RE: 158 Grant Street – 053-C-010 – R-6 Zone – application # 04-1306

I am in receipt of your application to build an addition and to change the use of this property from two to four family dwelling units. Your permit is denied because it is not meeting the requirements of the Zoning Ordinance and has not received an approval under site plan review as required.

DRAWING NUMBER: A-1

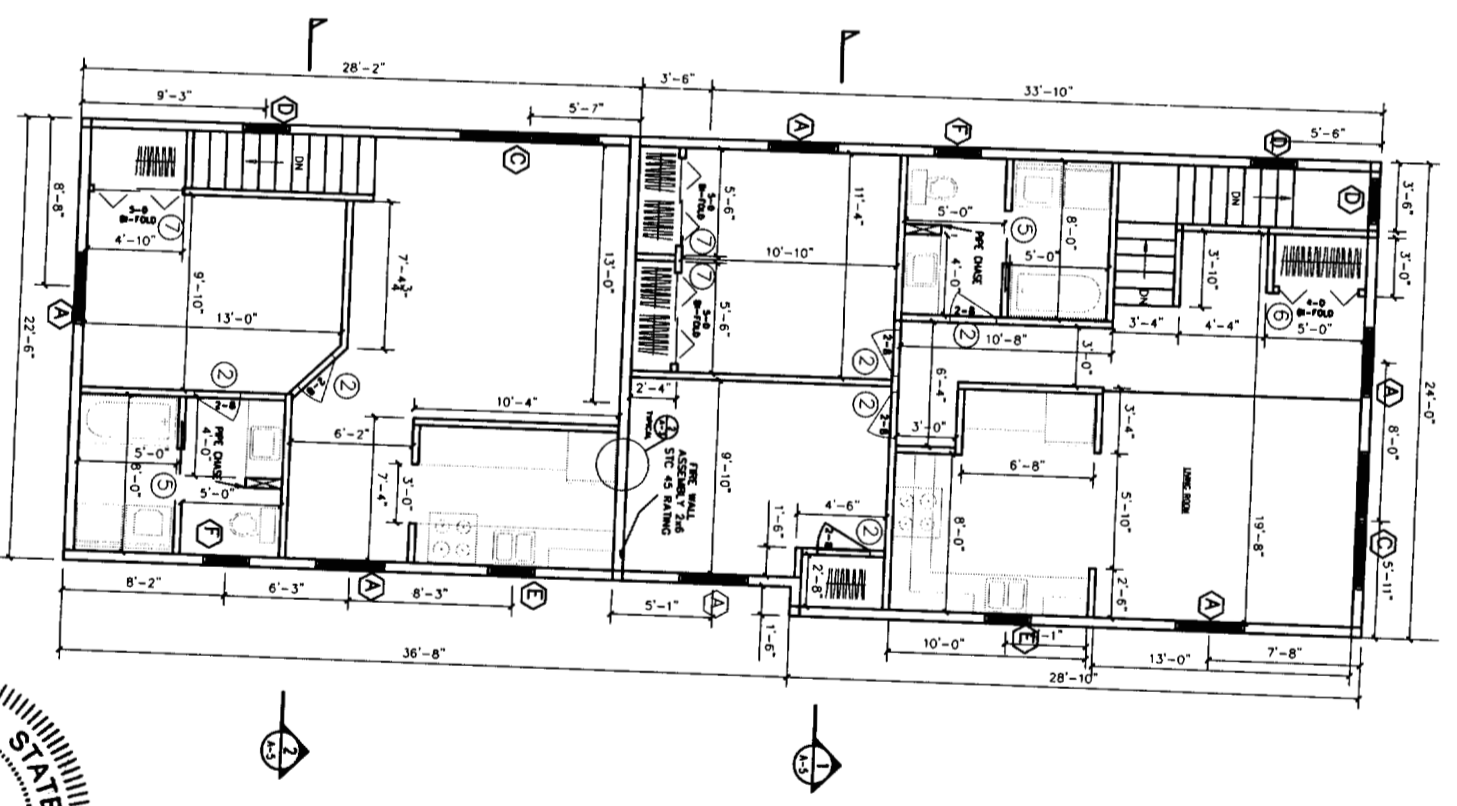
Section 14-136(a)2 of the ordinance requires that any alteration to a multifamily dwelling shall not result in any existing dwelling unit being reduced in size to less than one thousand (1,000) square feet of floor area. Your proposal shows that both existing units will be reduced to well under one thousand square feet.
